Land fronting, Turnbull Road, Fradley, Lichfield

**Application by Massey Limited for the variation of Condition 2 of planning permission
REF: 18/O1693/FUL**

This Application is for variation of Condition 2 of planning permission 18/O169/FUL, 28th October 2020. That planning permission is for the erection of 8no. dwellings and associated works.

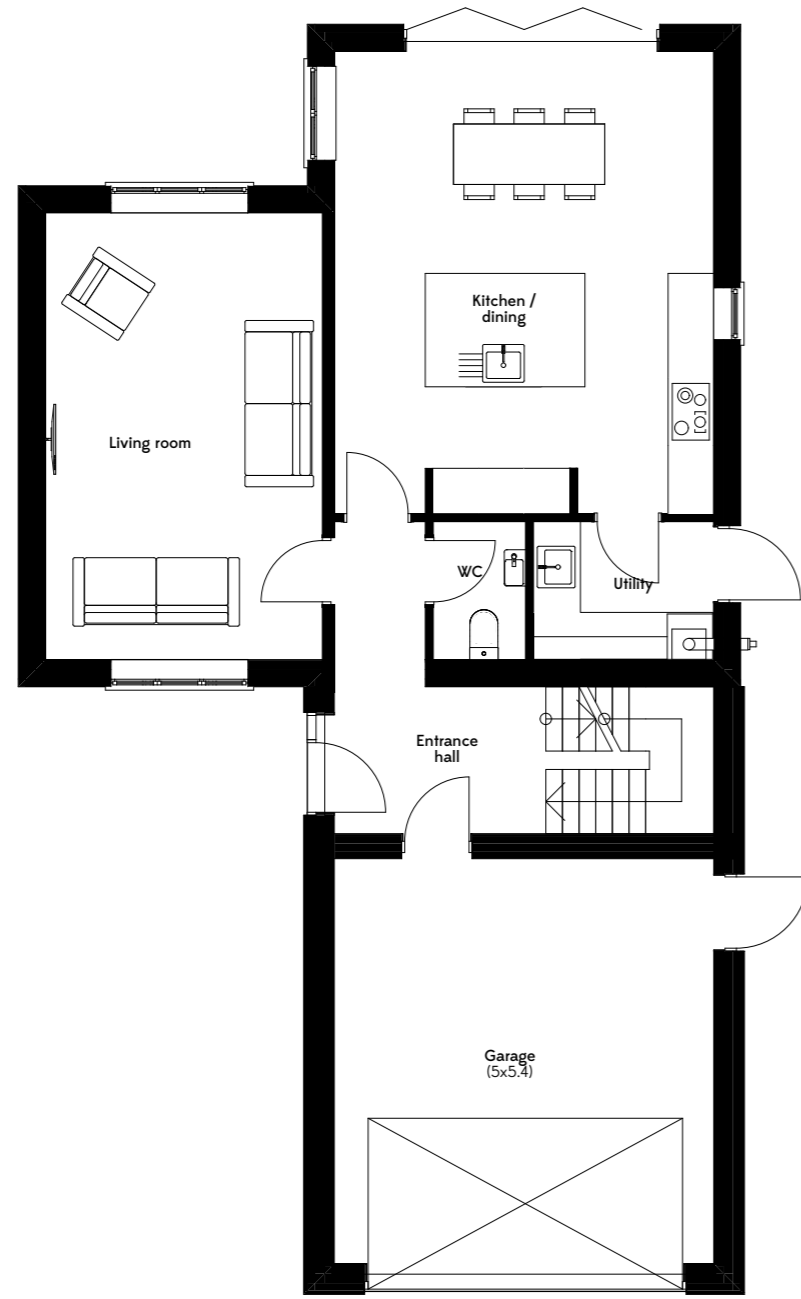
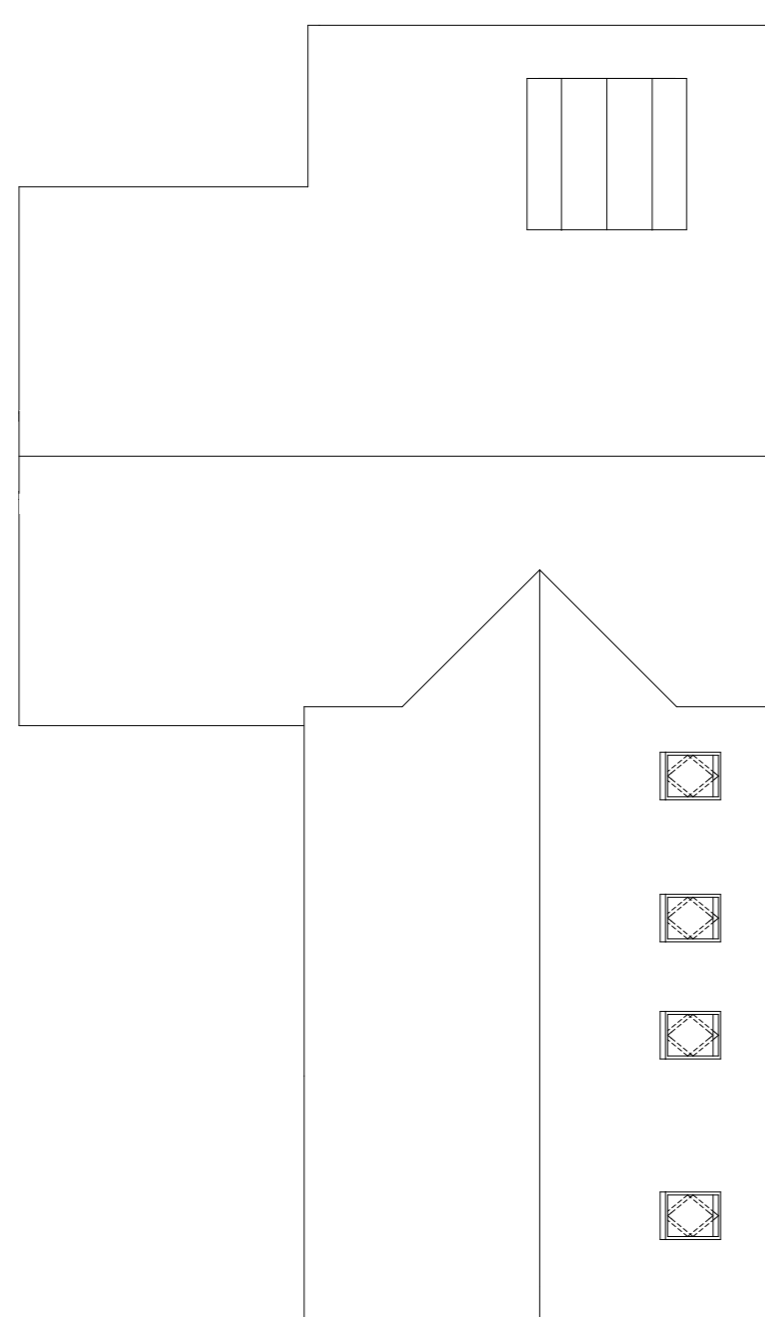
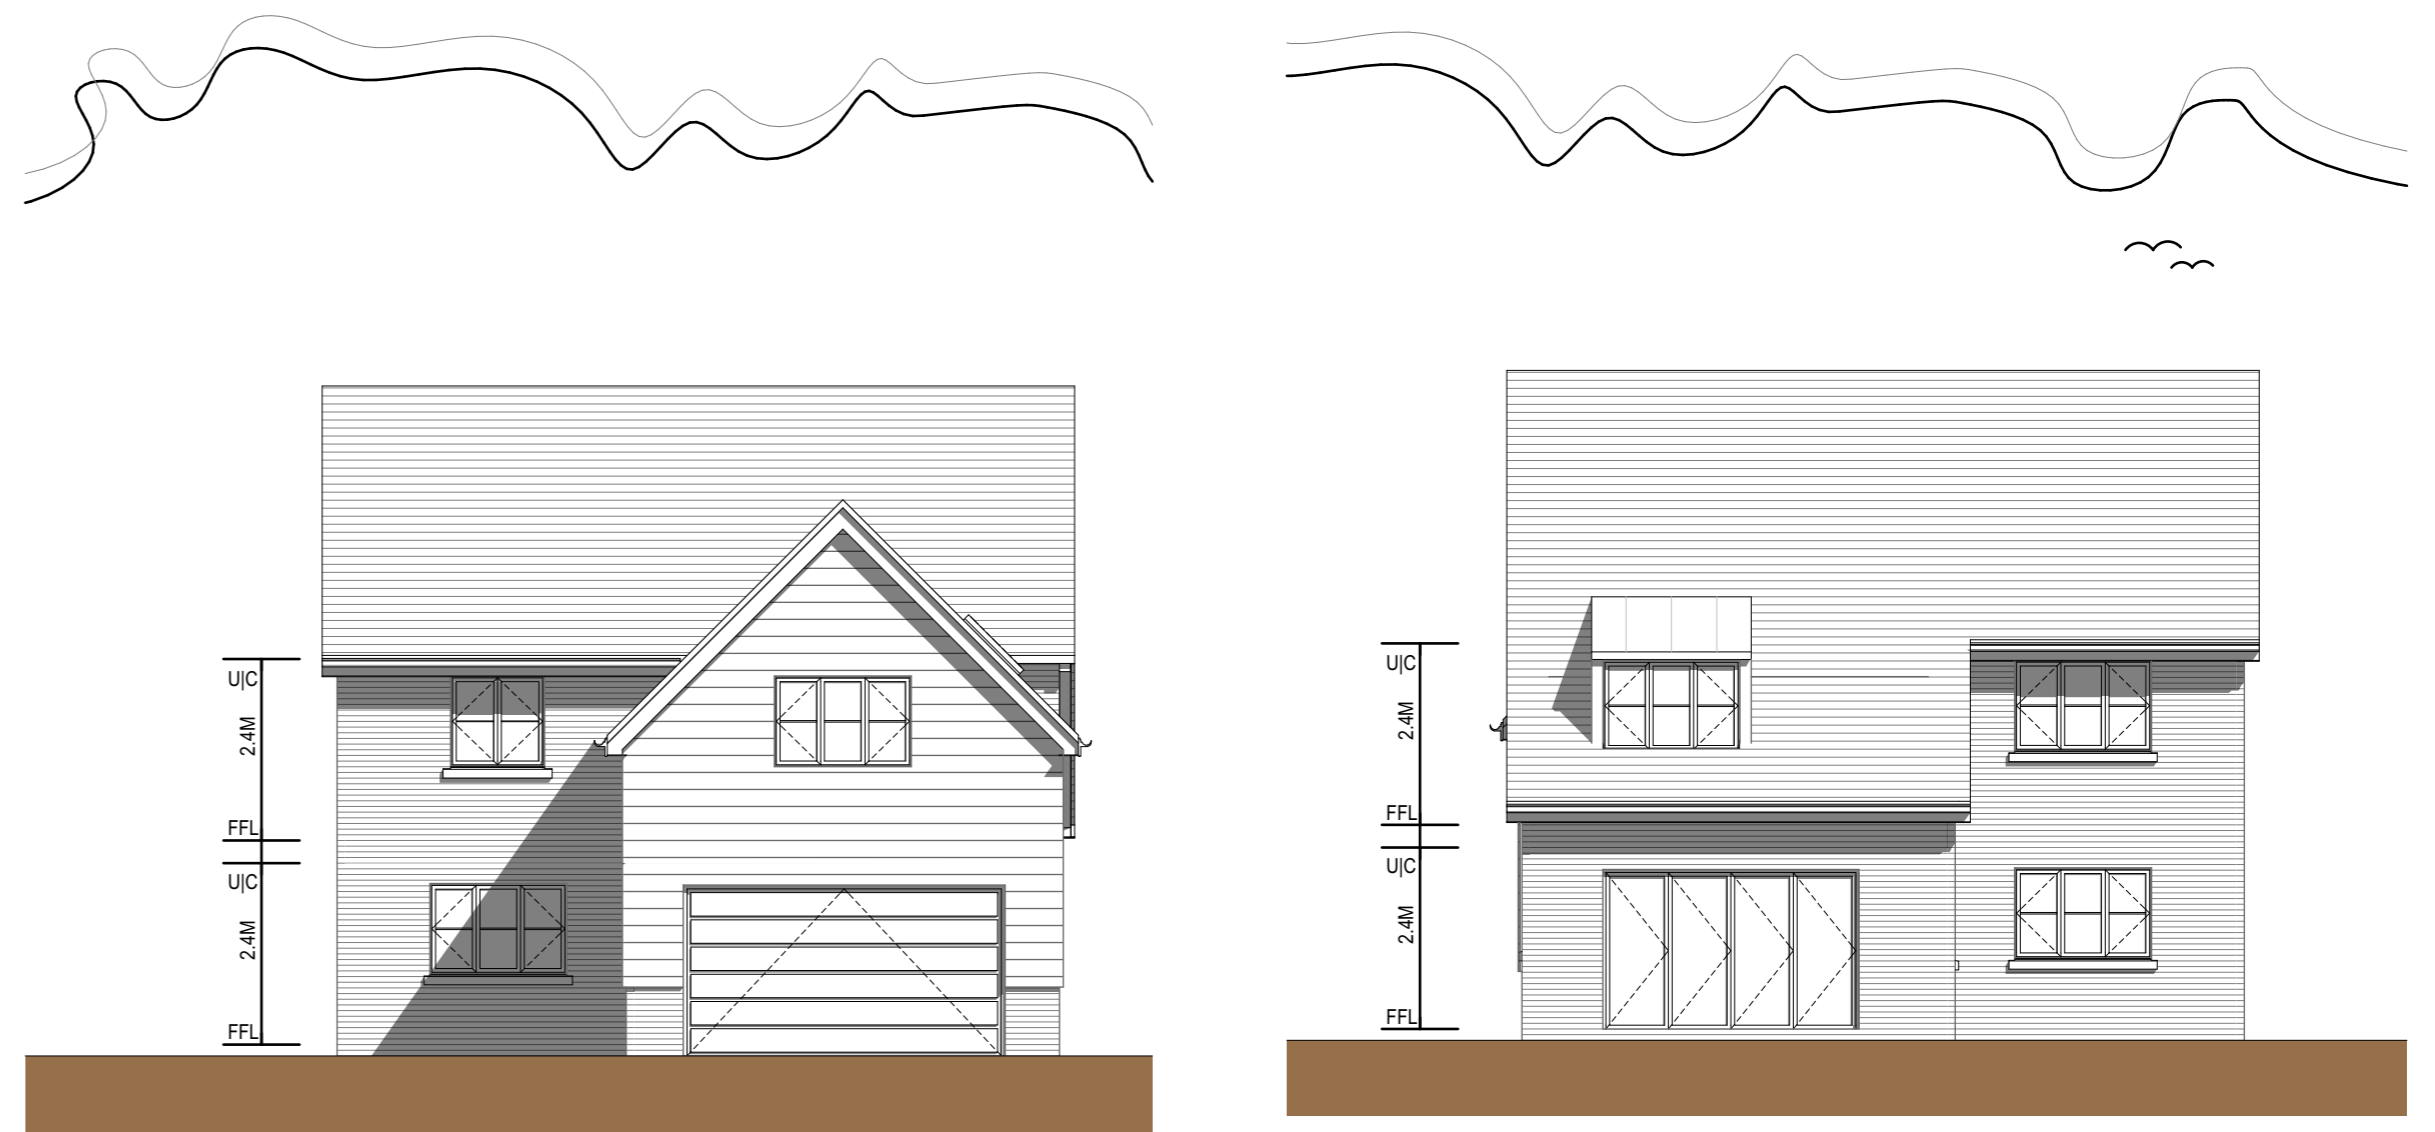
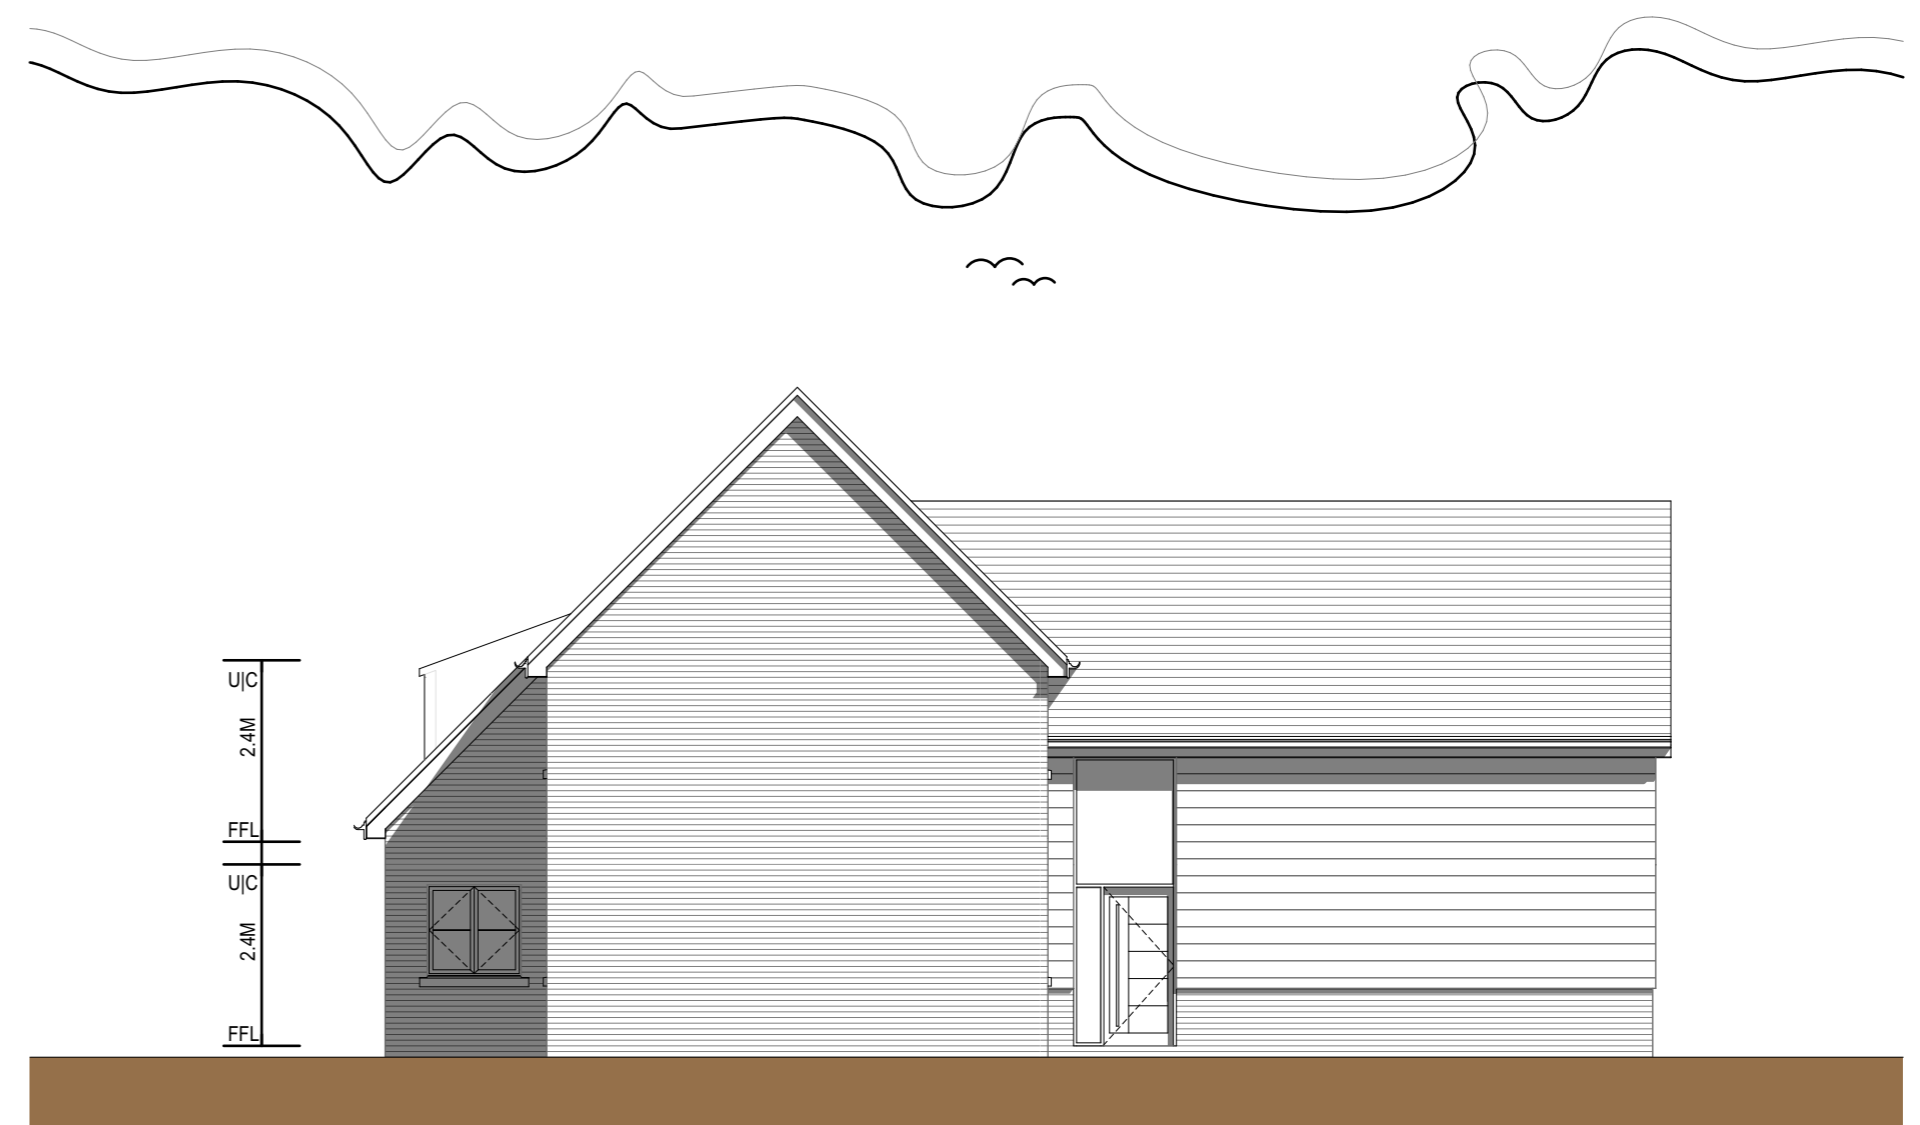
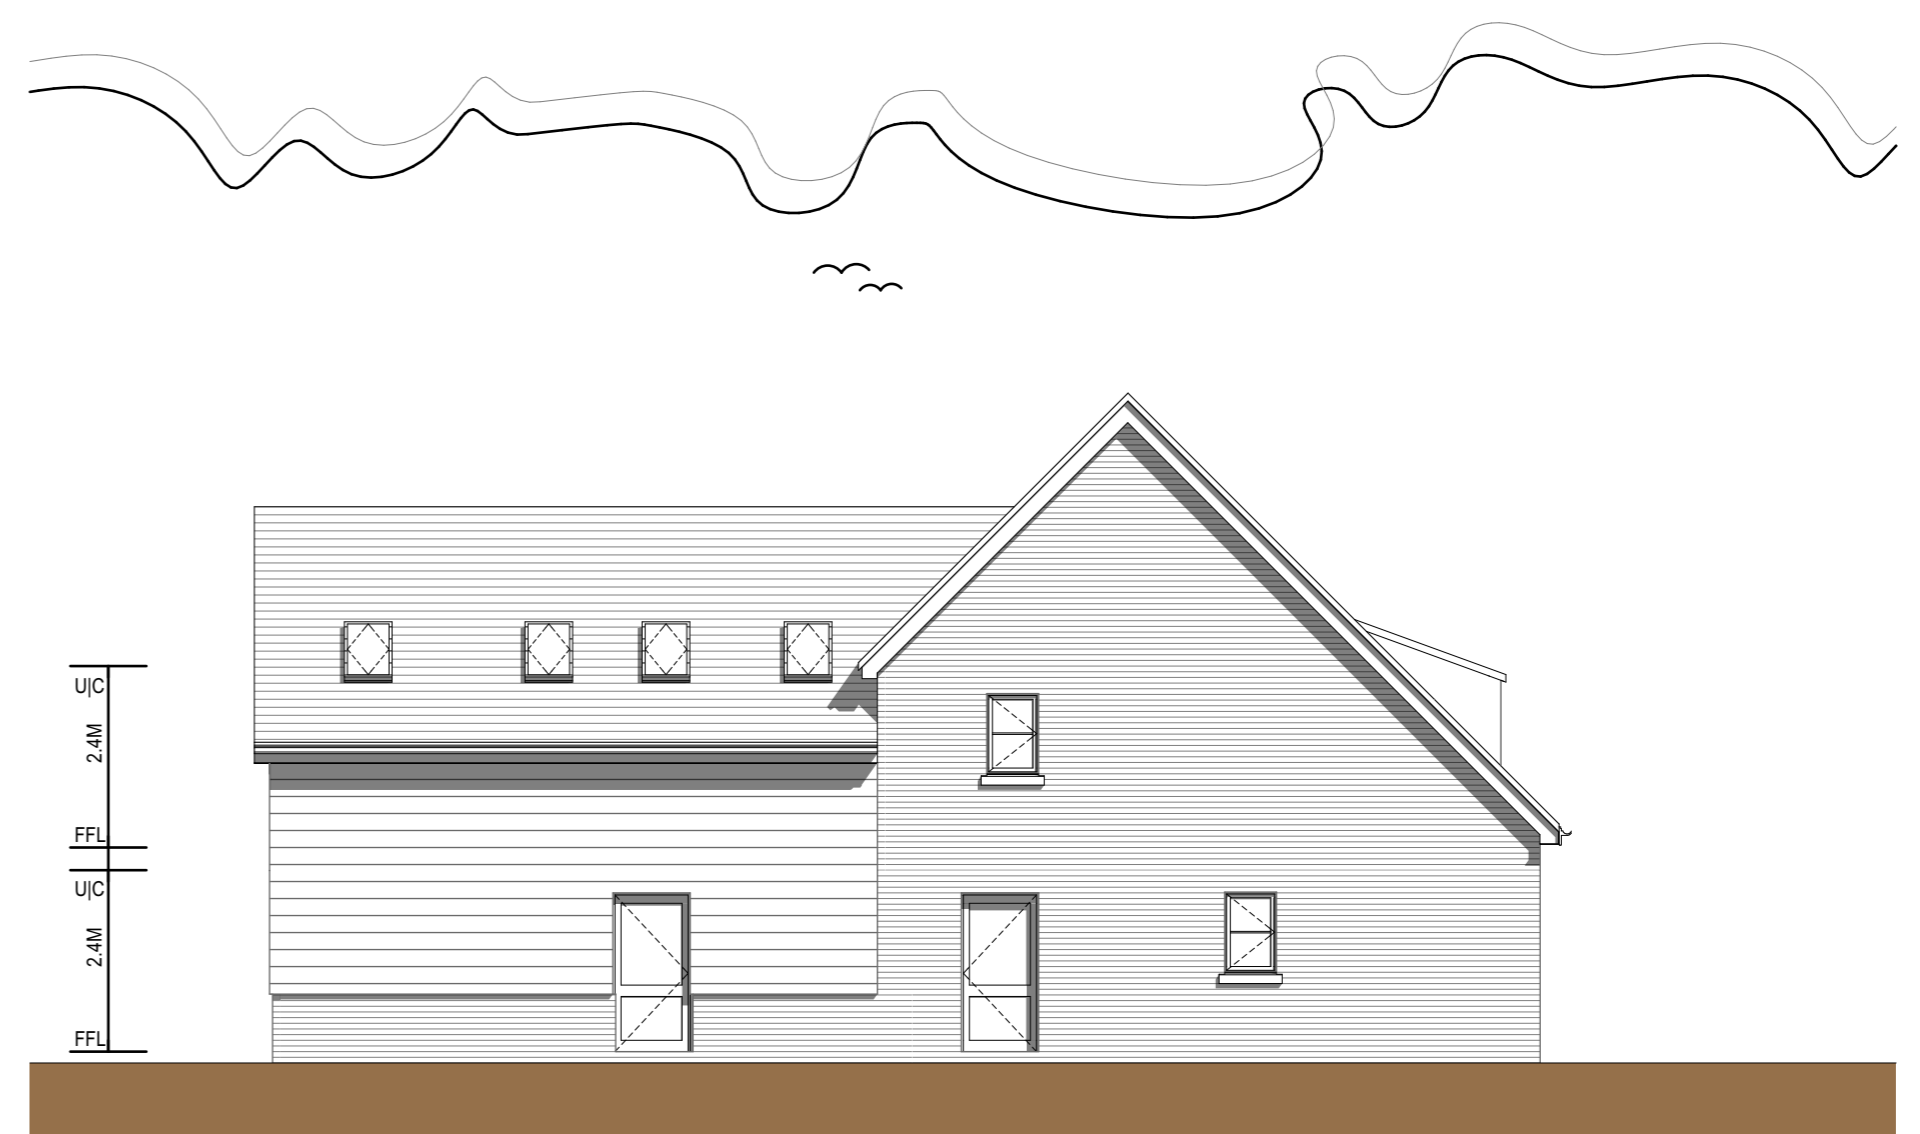
House Type 3

- GIA reduced from 231sqm to 173sqm.
- Overall width of house reduced. Internal layout revised to suit.
- Step in centre plan to rear of house omitted.
- Number of bedrooms reduced from 5 to 4.
- Log stove flue omitted.
- Eaves height of roof above garage / Bed 1 lowered.
- Roof line to rear of property altered to suit proposed internal layout. Dormer window added to bedroom 2.
